Subject: Urgent - Consultee Comments on planning applications LU/221/14/PL, LU/222/14/PL, LU/223/14/PL, LU/224/14/PL and LU/227/14/PL

The Town Council's Planning and Transportation Committee considered planning applications LU/221/14/PL, LU/222/14/PL, LU/223/14/PL, LU/224/14/PL and LU/227/14/PL at their meeting held on 26th August 2014.

DRAWING NO. J48.22/02
Scale: 1:200 at A3
Added to by: NL
03/02/2014

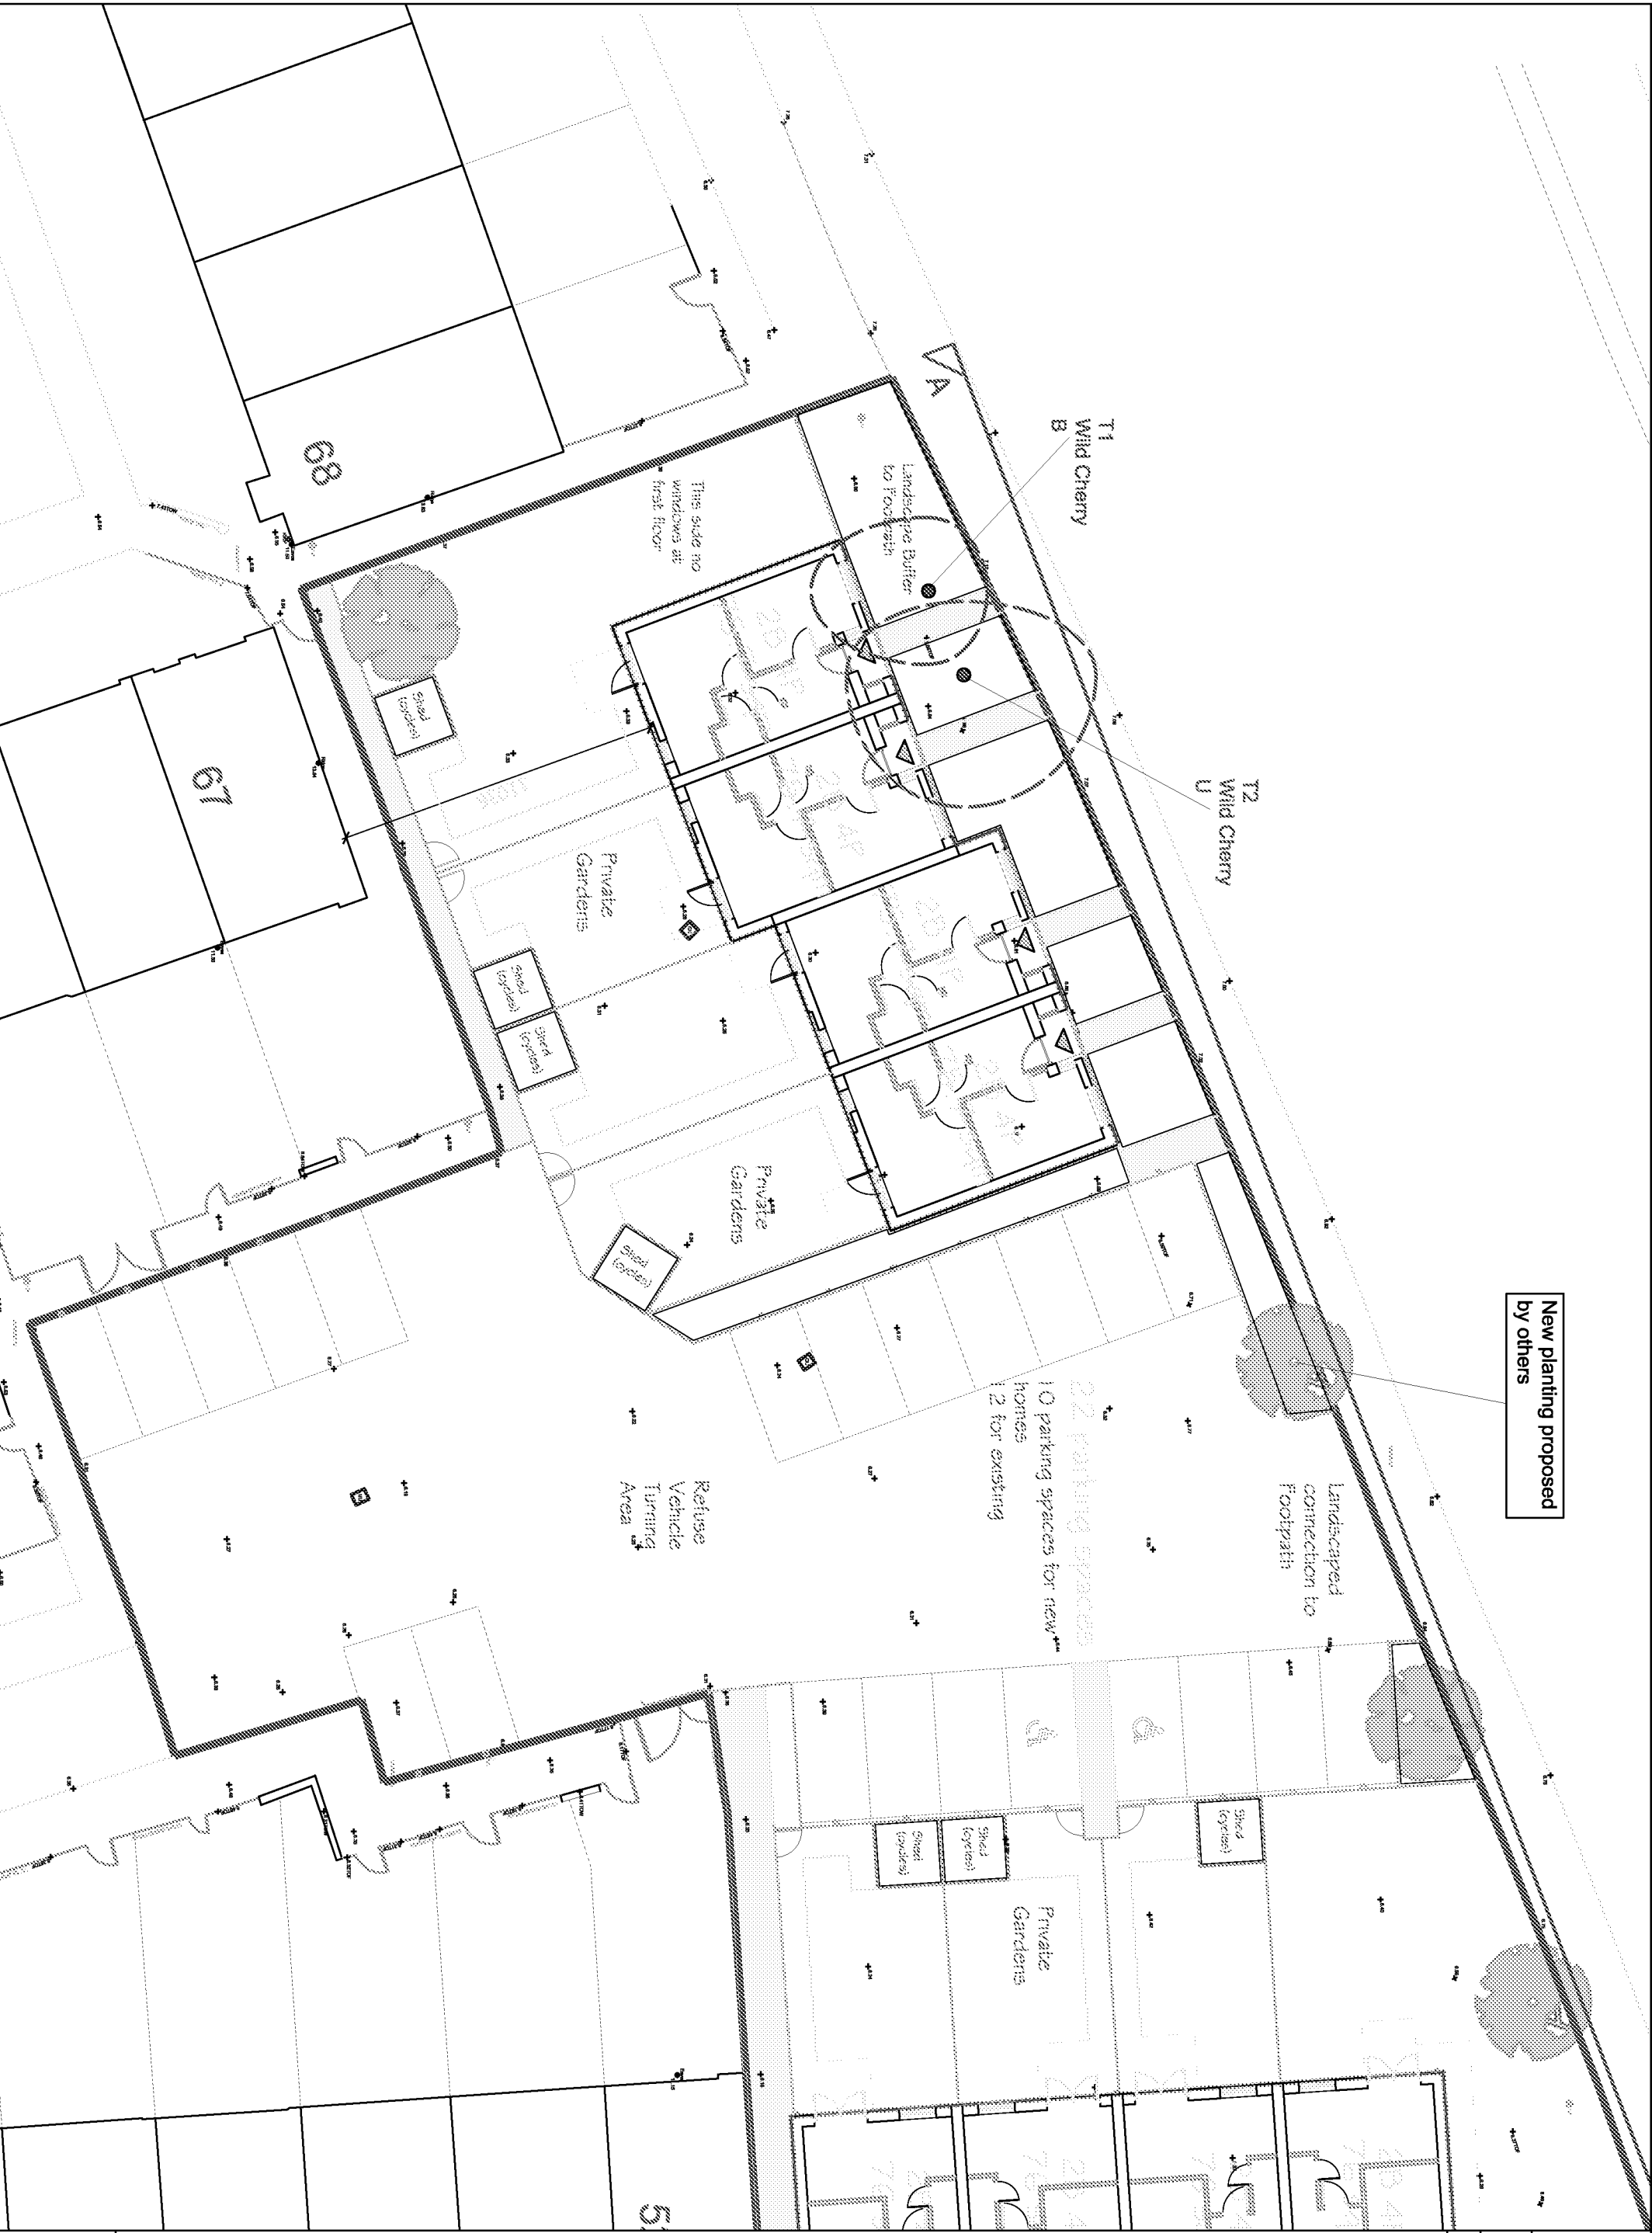
- The estimated parking on each site are based on conclusions from one parking needs survey carried out the week before Christmas 2013 that on street parking could be reduced.
- No displaced parking due to development will occur based either on full current onsite capacity or observed levels (LU/223/14)
- New offsite parking uses the green strip/verge to edge of Greenfields (LU/227/14)
- The proposed new offsite parking is not as accessible to residents of existing housing as the current parking.
- For the new houses that are facing northwards access to parking for shopping etc. is very poor

Figure 8: Daytime Noise Map

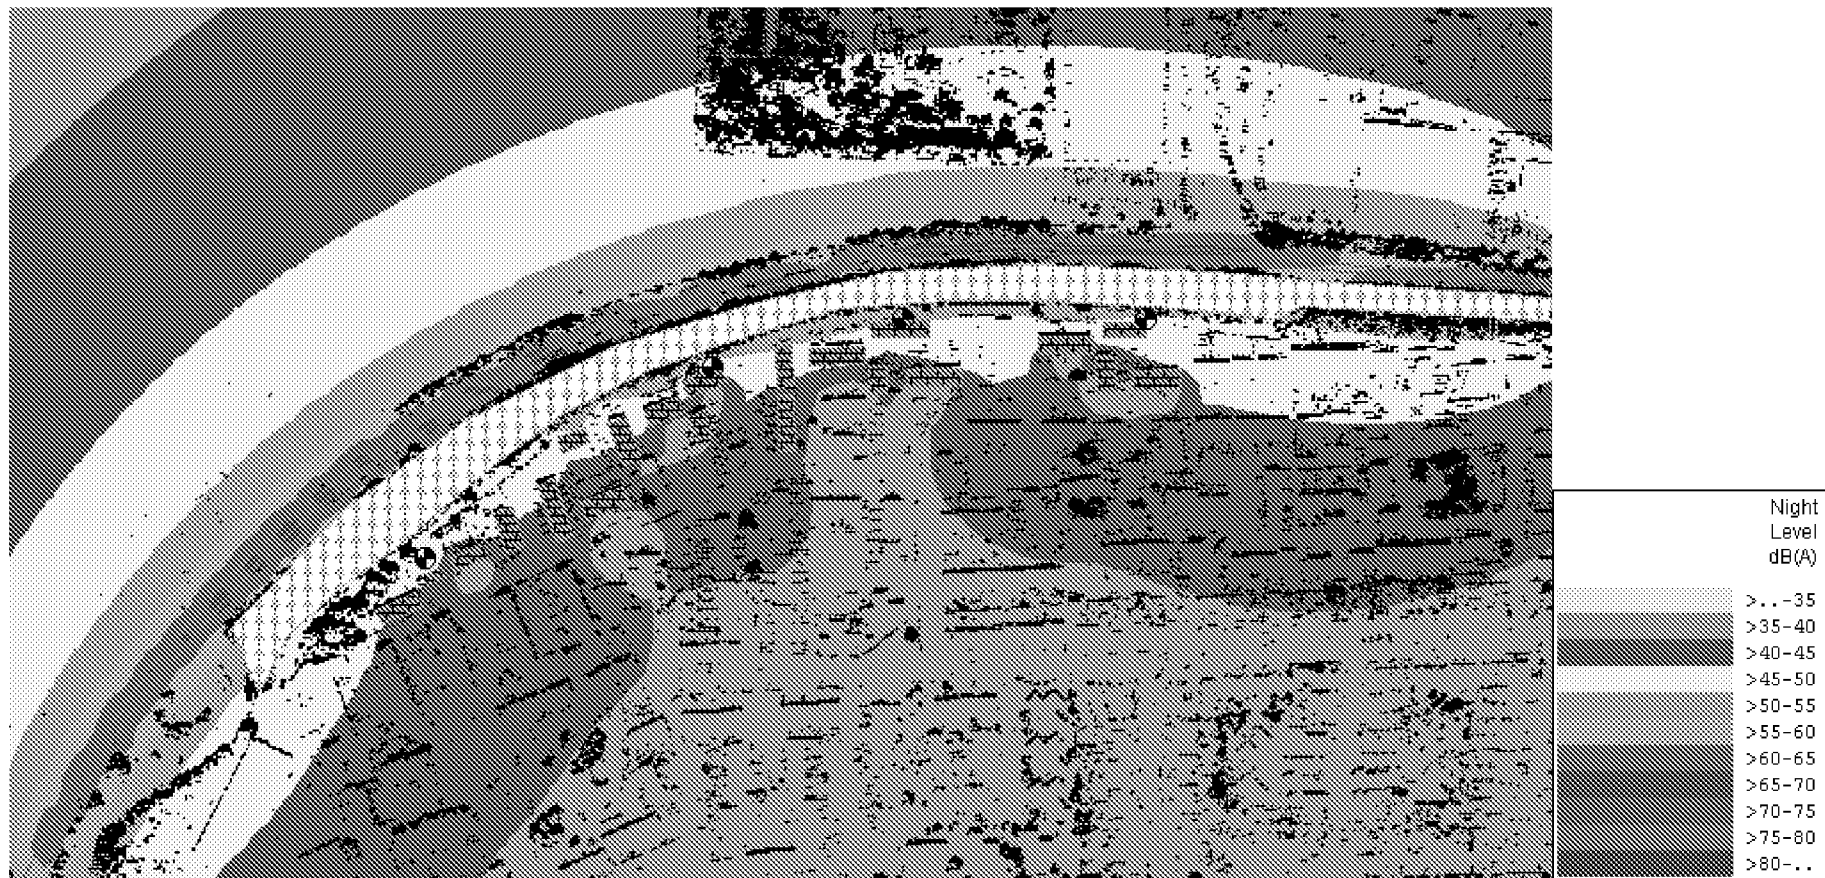
- These conclusions particularly affect houses that face towards the north and have very small front gardens

Permeability Graph TP4b Test 2

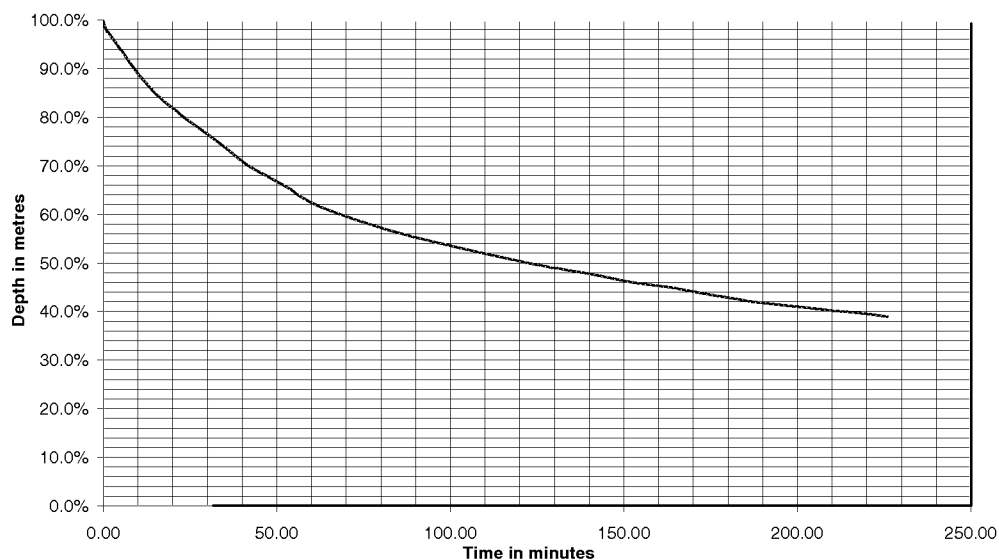
- The infiltration testing of sites LU/221/14 & LU/222/14 showed the best results but these were still not good. Is it appropriate to build more houses if this is a problem?
- It appears that at sites LU/224/14, LU/223/14 & LU/222/14, in spite of renewed testing are showing very slow land drainage. Is it appropriate to build more houses if this is a problem?
